Response to Planning Application

From: Arun District Council Greenspace

Application ref: P/153/21/RES

Location: Land South of Summer Lane and West of Pagham Road Pagham

LEAP (Local Equipped Area of Play) - Design Approach

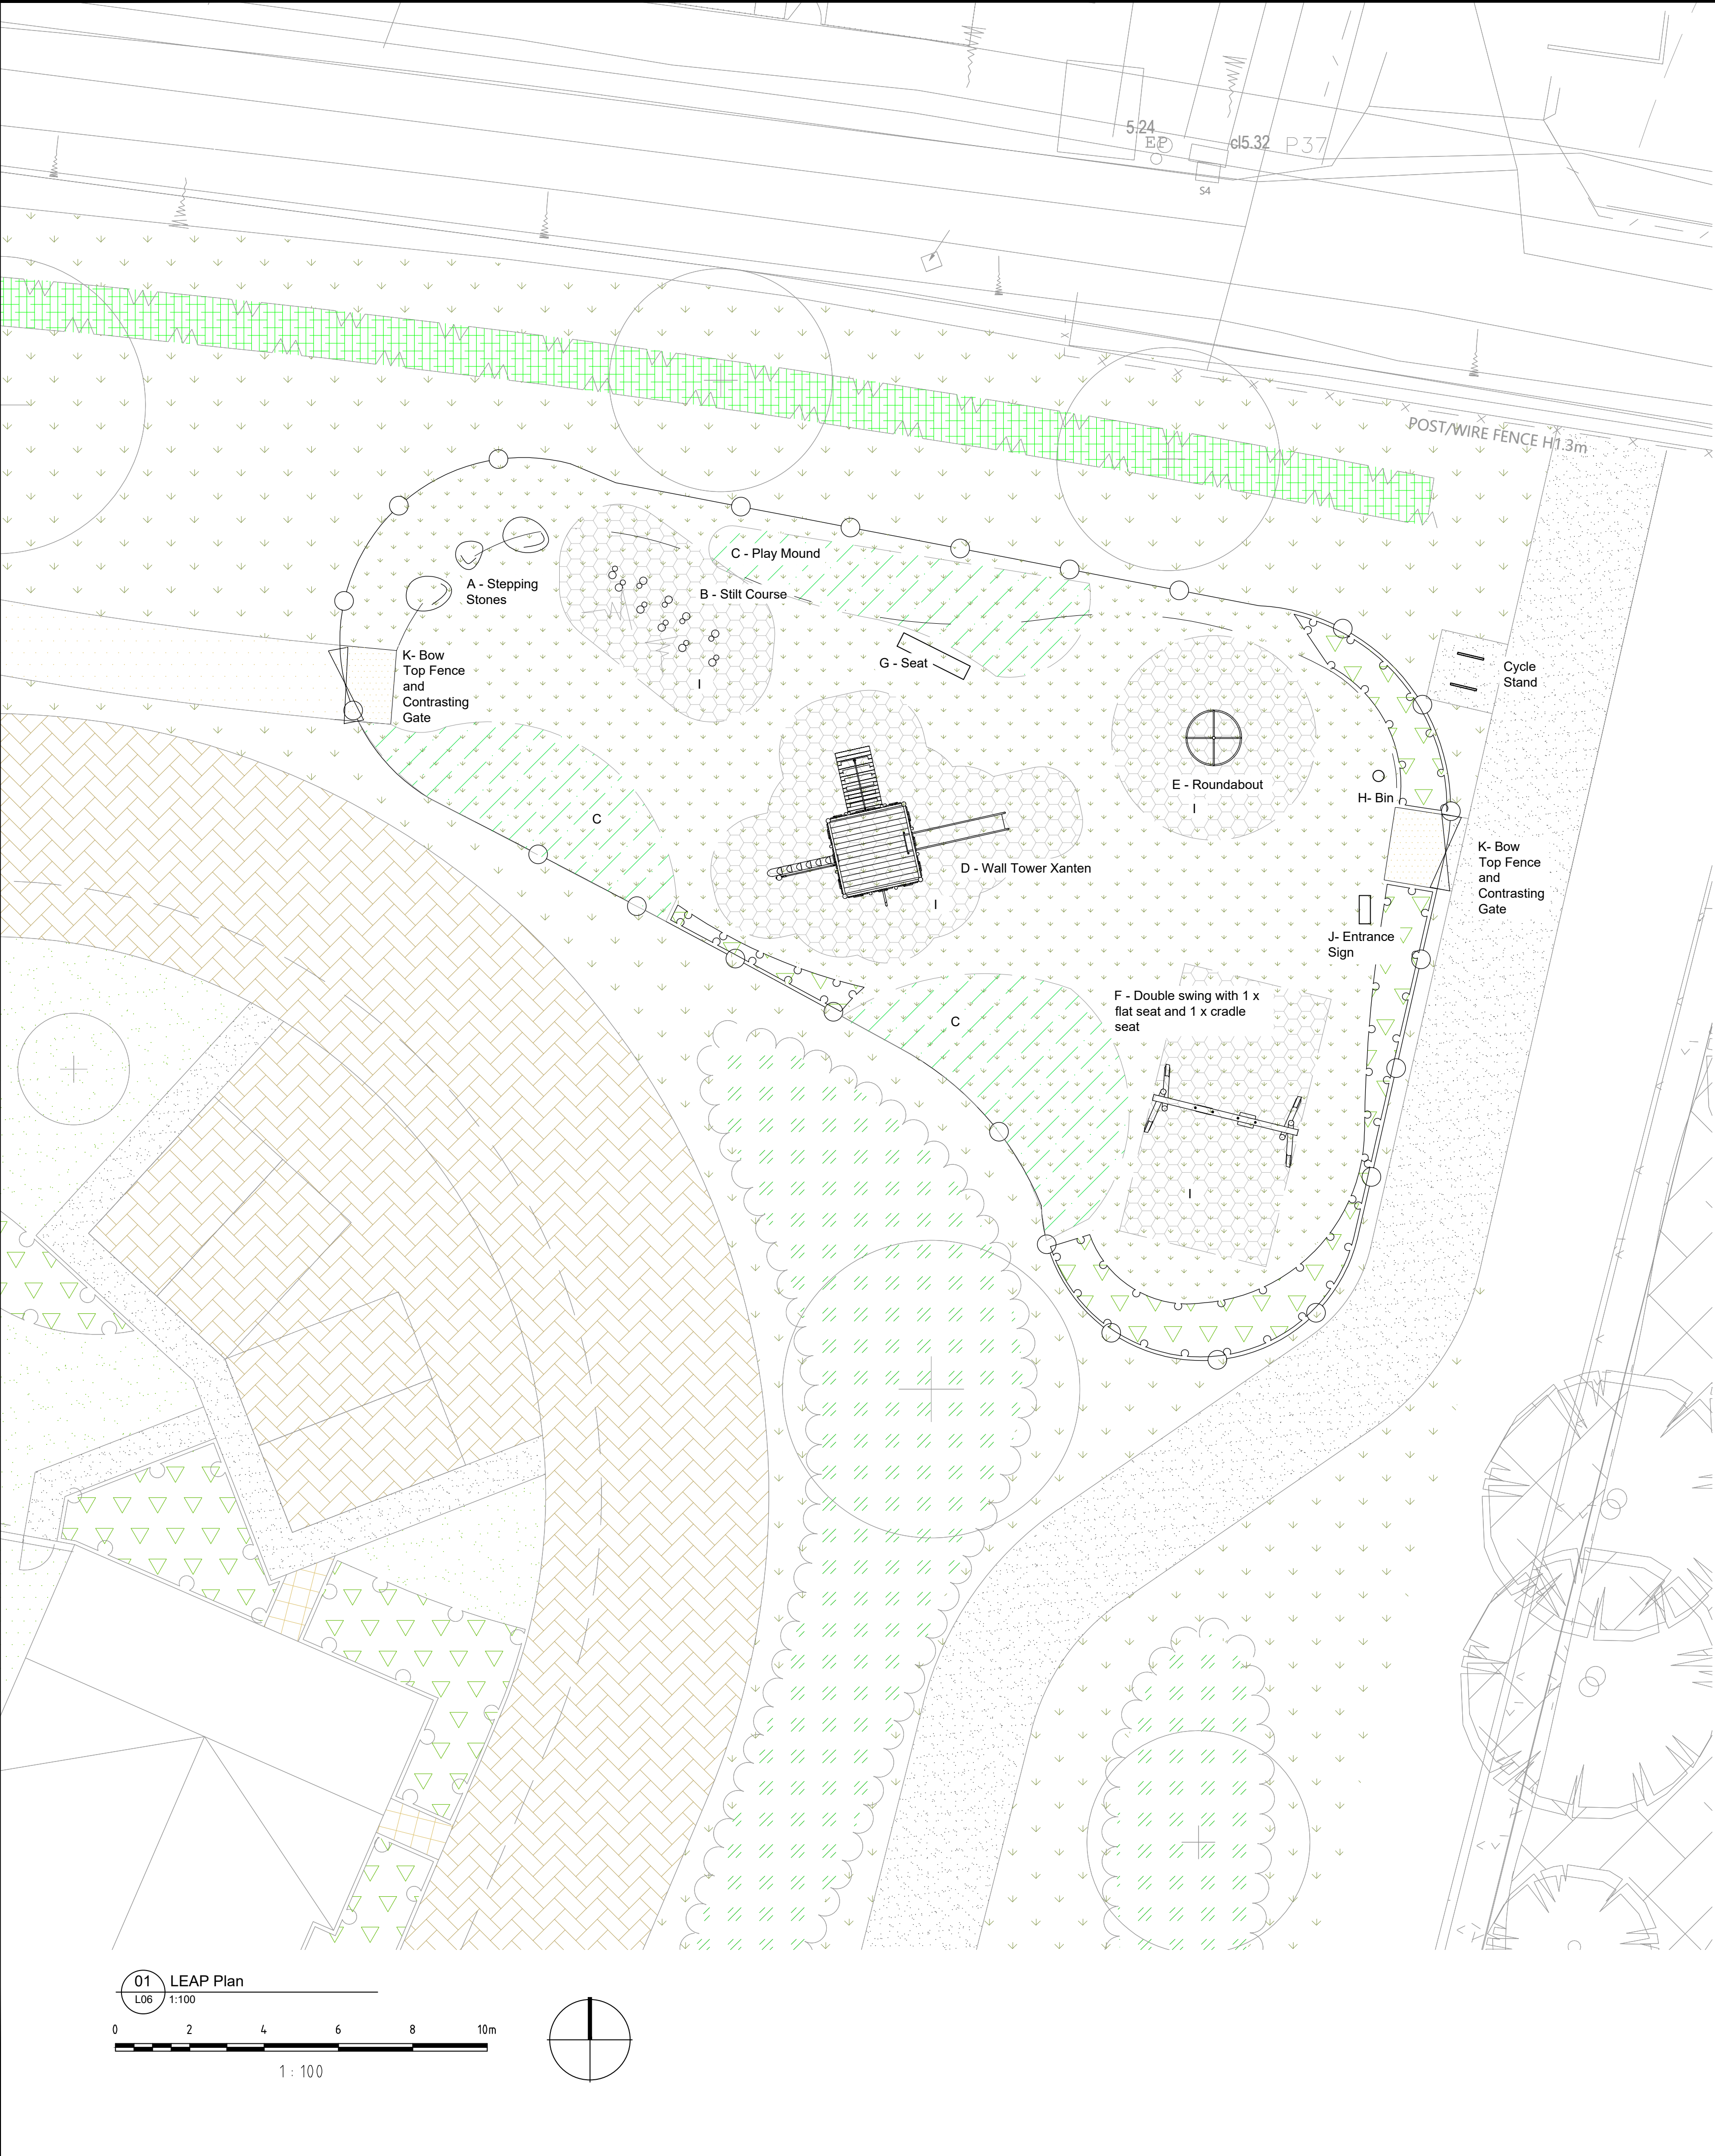
The LEAP Northern Parcel DD494L06 Rev B design appears inadequate in inclusive an accessible play in line with the Arun Design Guide Jan 2021. The equipment appears limited in play experience offered. Swings shown as two flat seats, which are less accessible and exclude the use by very young children (ie the introduction of basket and inclusive swings cater to a wider audience). The play detail fails to demonstrate what is proposed re pathway connection and surfacing to POS areas shown as self-binding gravel would not be recommended due to maintenance issues in high traffic areas for particularly all-weather accessibility and wheeled users. The indicated grass play mounds have no contour or height detail or detail of how these then interface with the adjacent fencing.

Enhanced LEAP (Local Equipped Area of Play) - Design Approach

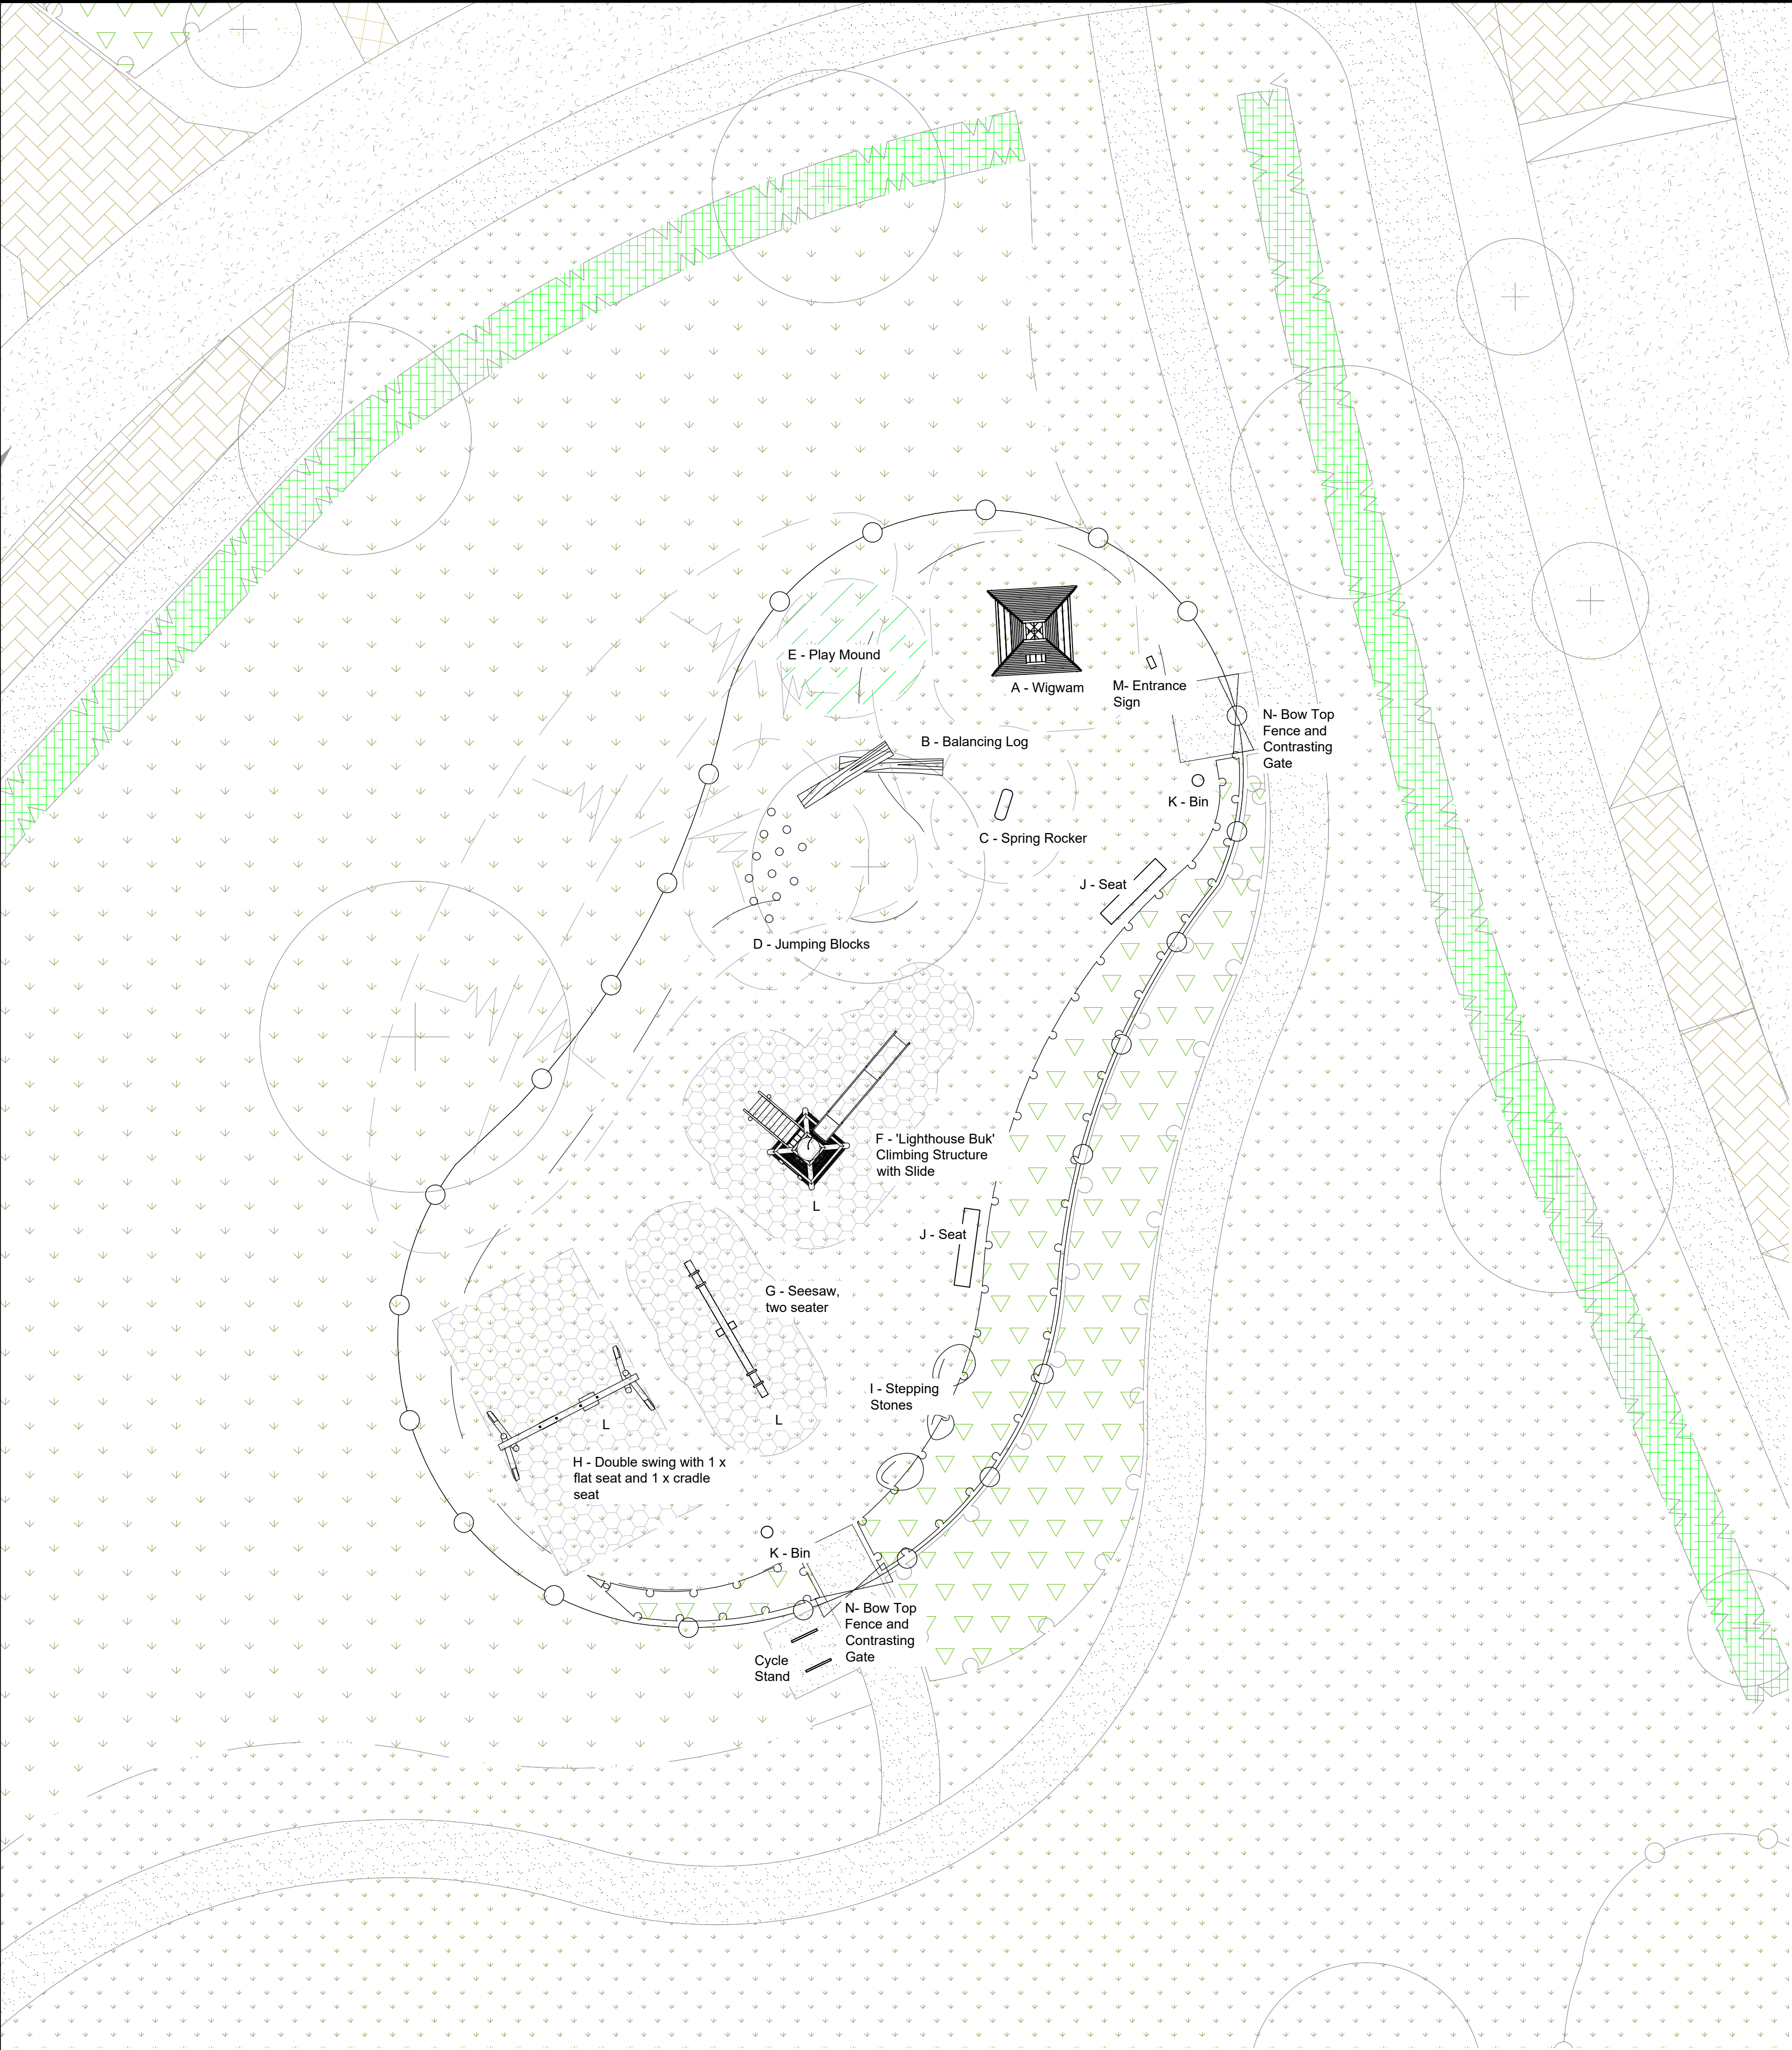
The ELEAP Southern Parcel DD494L07 Rev B design appears inadequate in inclusive an accessible play in line with the Arun Design Guide Jan 2021. The equipment appears repetitive of the Northern Parcel LEAP and limited in variety of play experience offered. Swings again shown as two flat seats, which are less accessible and low value play items have been incorporated ie balance logs and jumping blocks. The play detail fails to provide an exciting and challenging play offer required by an ELEAP – Enhanced LEAP, for this many dwellings. The drawing has failed to demonstrate what is proposed re safety surfacing or pathway connection. The indicated grass play mounds again have no contour or height detail or detail of how these then interface with the adjacent fencing.
